Our ref: OUT25/11056

Subject: Metropolitan Coal Longwalls 317 and 318 Modification 4 (MP08_0149) – Modification Report

Detailed advice to DPHI Planning & Assessment regarding the Metropolitan Coal LW 317 & 318 Modification 4 – Modification Report

Peabody
METROPOLITAN COAL
Relocated Ventilation Shaft 4
General Arrangement

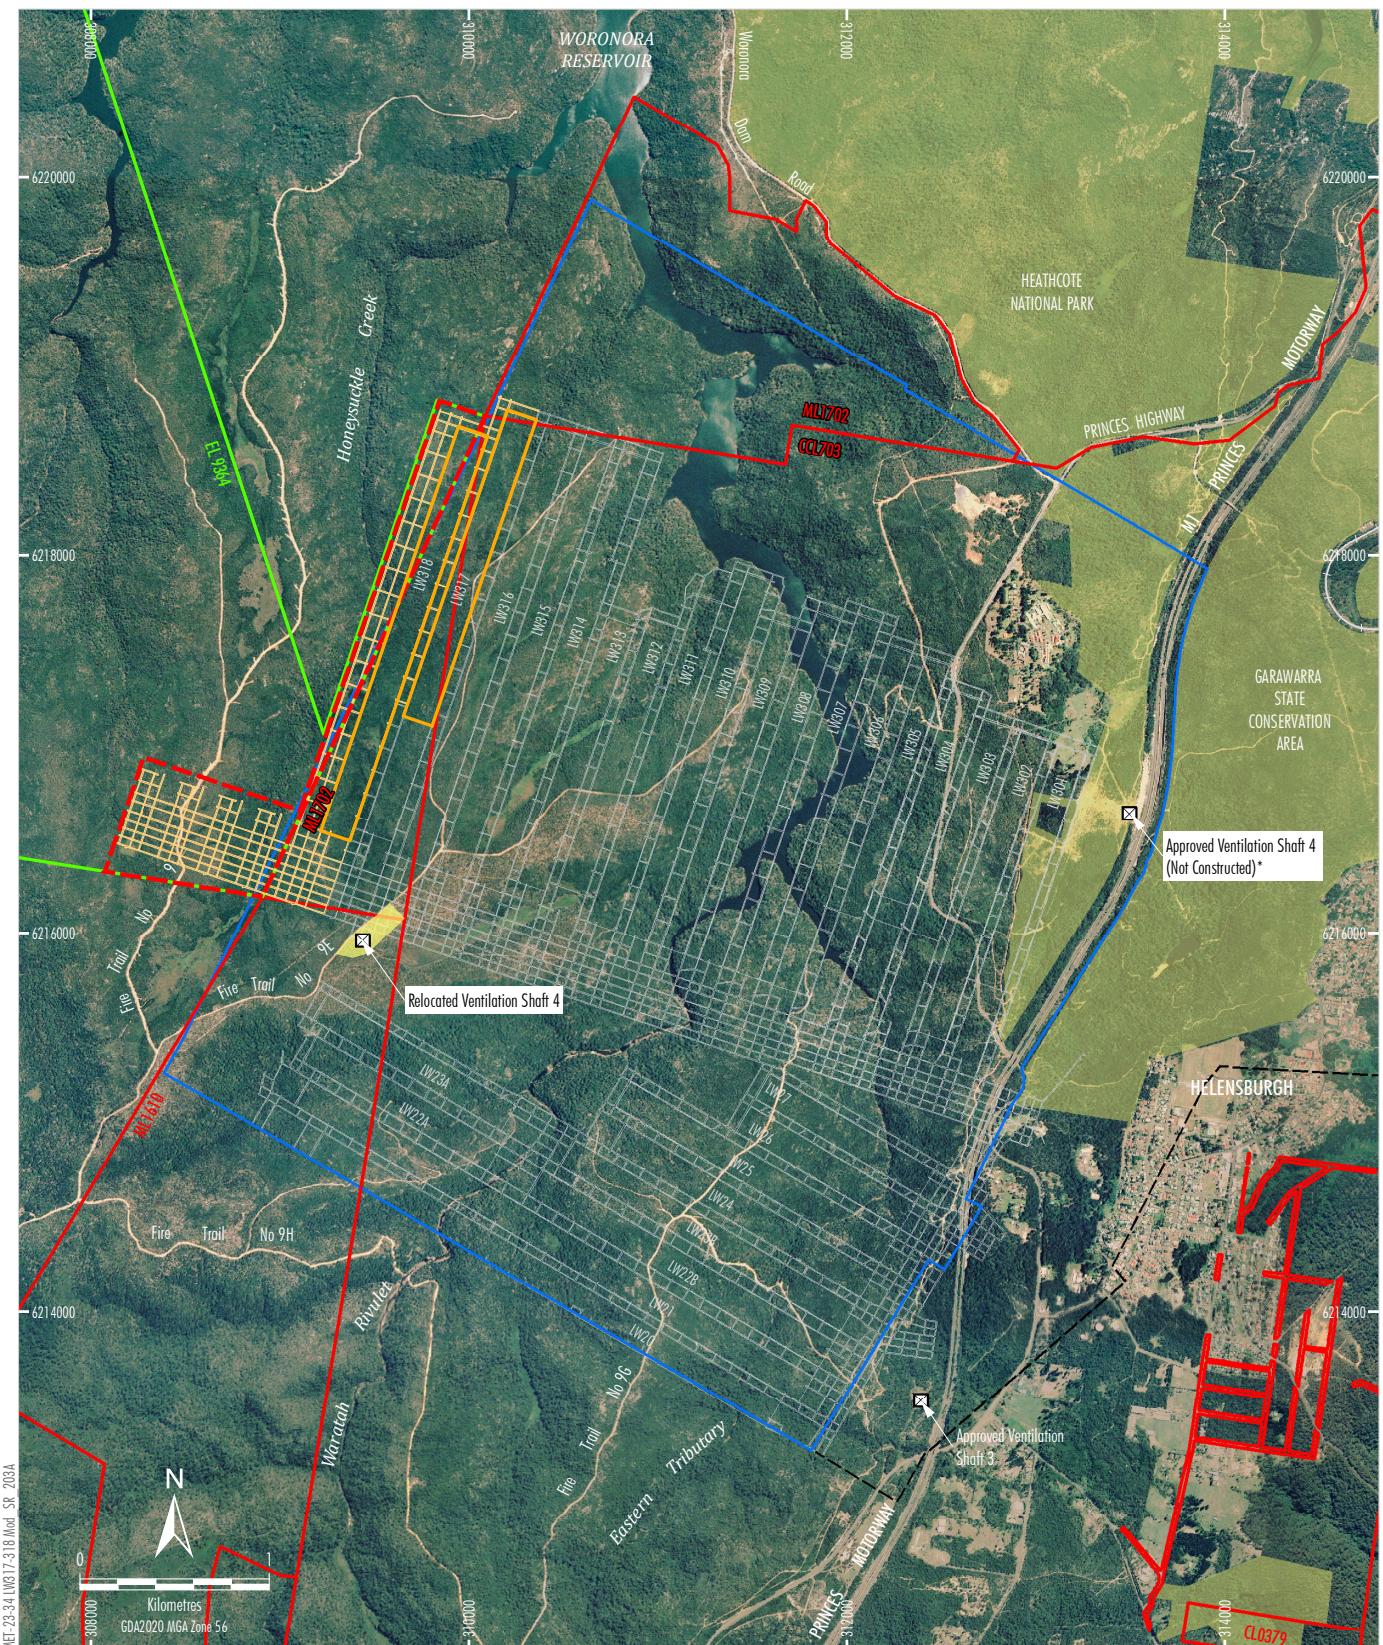
That DPHI requests the proponent to provide further assessment of the groundwater take and impacts from construction and operation of the new location of ventilation shaft 4. The assessment needs to address the requirements of the NSW Aquifer Interference Policy.

The impact assessment of the relocated Ventilation Shaft 4 is inadequate.

Ventilation shafts require excavation through the full depth of overburden and can directly intersect groundwater systems that sustain surrounding swamps. Depending on their placement, shafts can act as preferential pathways for vertical drainage, lowering local water tables and reducing the capacity of adjacent swamps to maintain saturation. This risk is particularly acute where shafts are situated near groundwater-dependent ecosystems, yet the current assessment does not adequately consider the implications for nearby upland swamps, particularly S92.

LEGEND
Mining Lease Boundary
Railway
Indicative Access Tracks
Ongoing Revegetation and Stabilisation Works Area
Extent of Approved Disturbance Area
NPWS Managed Land

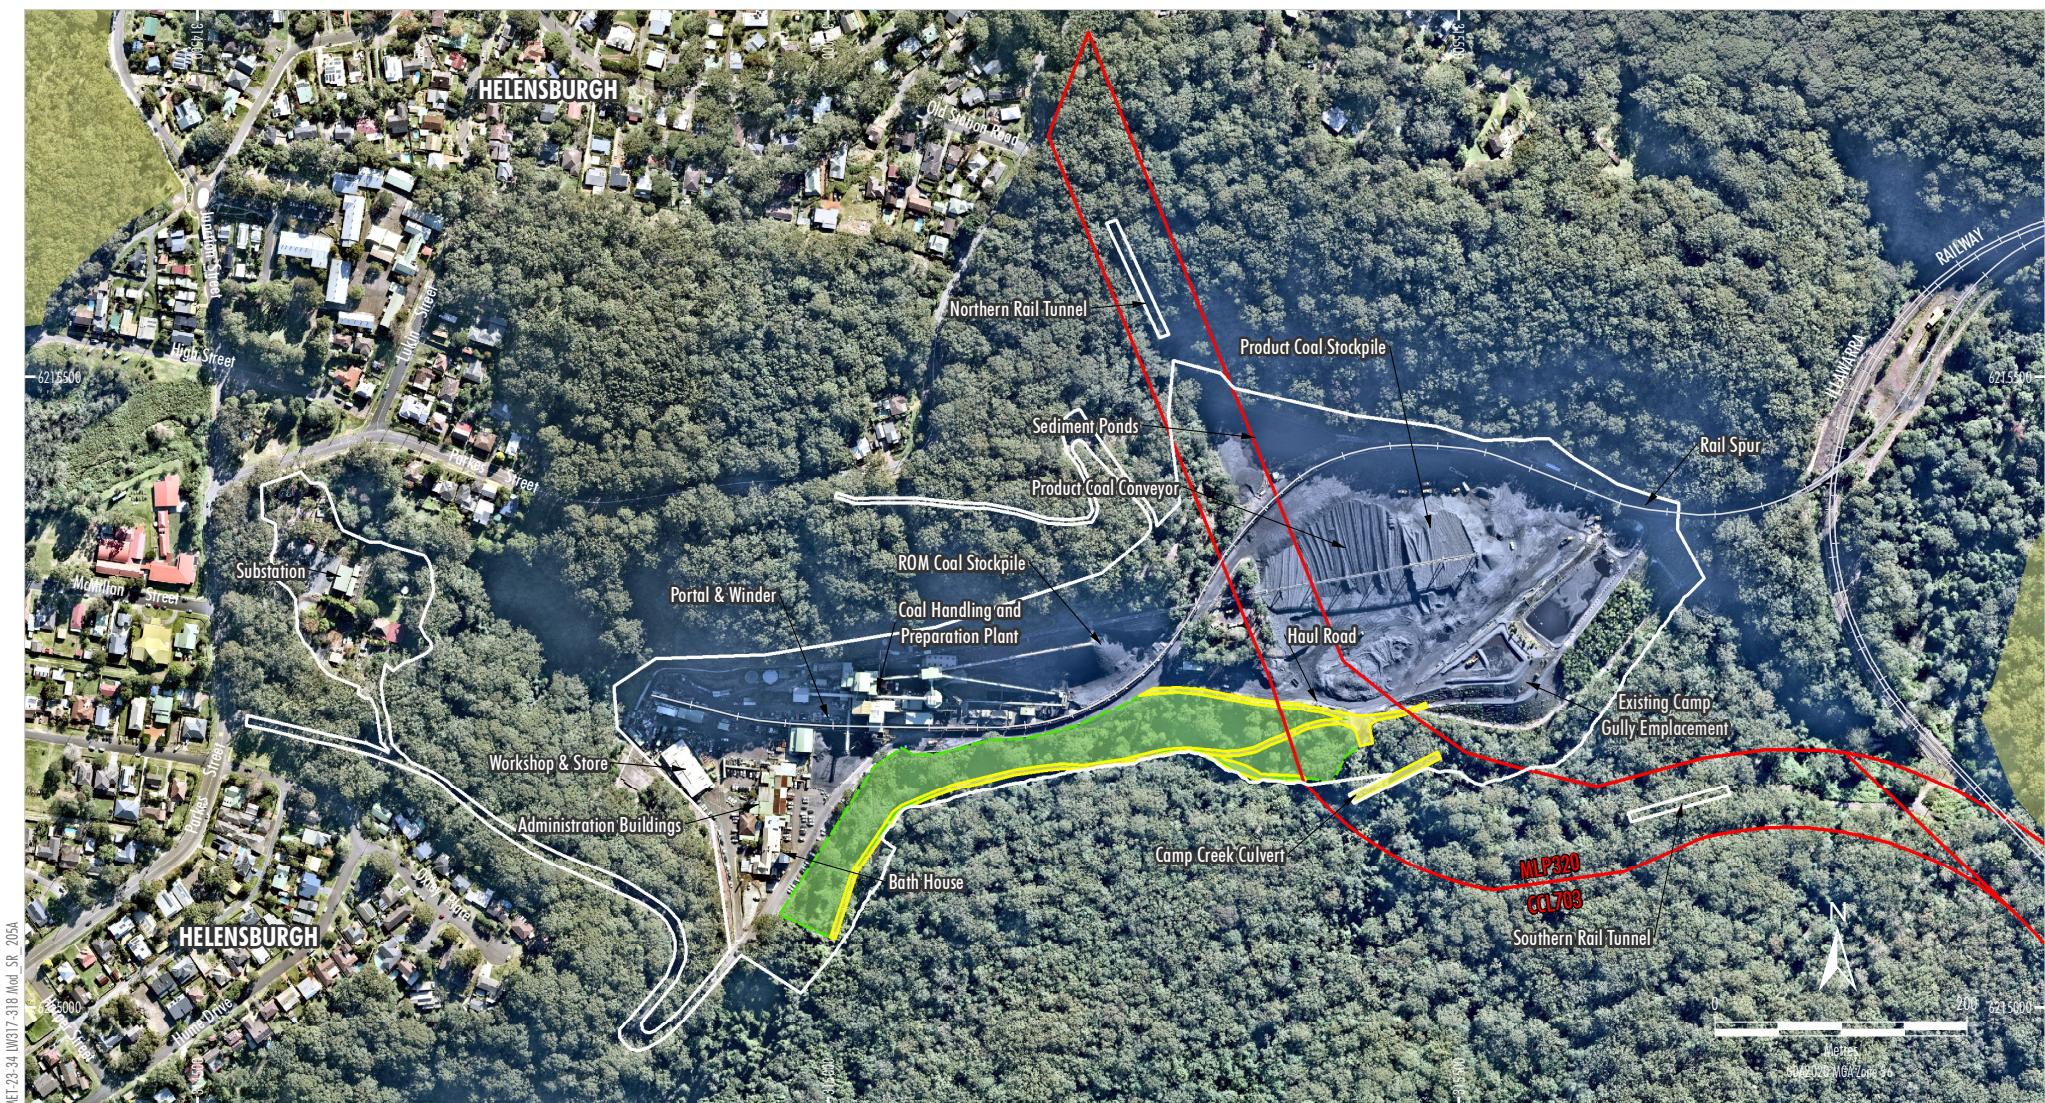
Access tracks and on-going stabilisation and revegetation works are proposed on waterfront land at Camp Gully, Helensburgh. The scope of works undertaken at this site is not clear, and should be undertaken in accordance with all relevant Guidelines for Controlled Activities on Waterfront land (2022). These guidelines are accessible at: <https://water.dpie.nsw.gov.au/our-work/licensing-and-approvals/controlled-activity-approvals#guidelines-for-controlled-activity-approvals>

That DPHI requests the proponent to ensure works on waterfront land are undertaken in accordance with the Guidelines for Controlled Activities on Waterfront Land (2022).
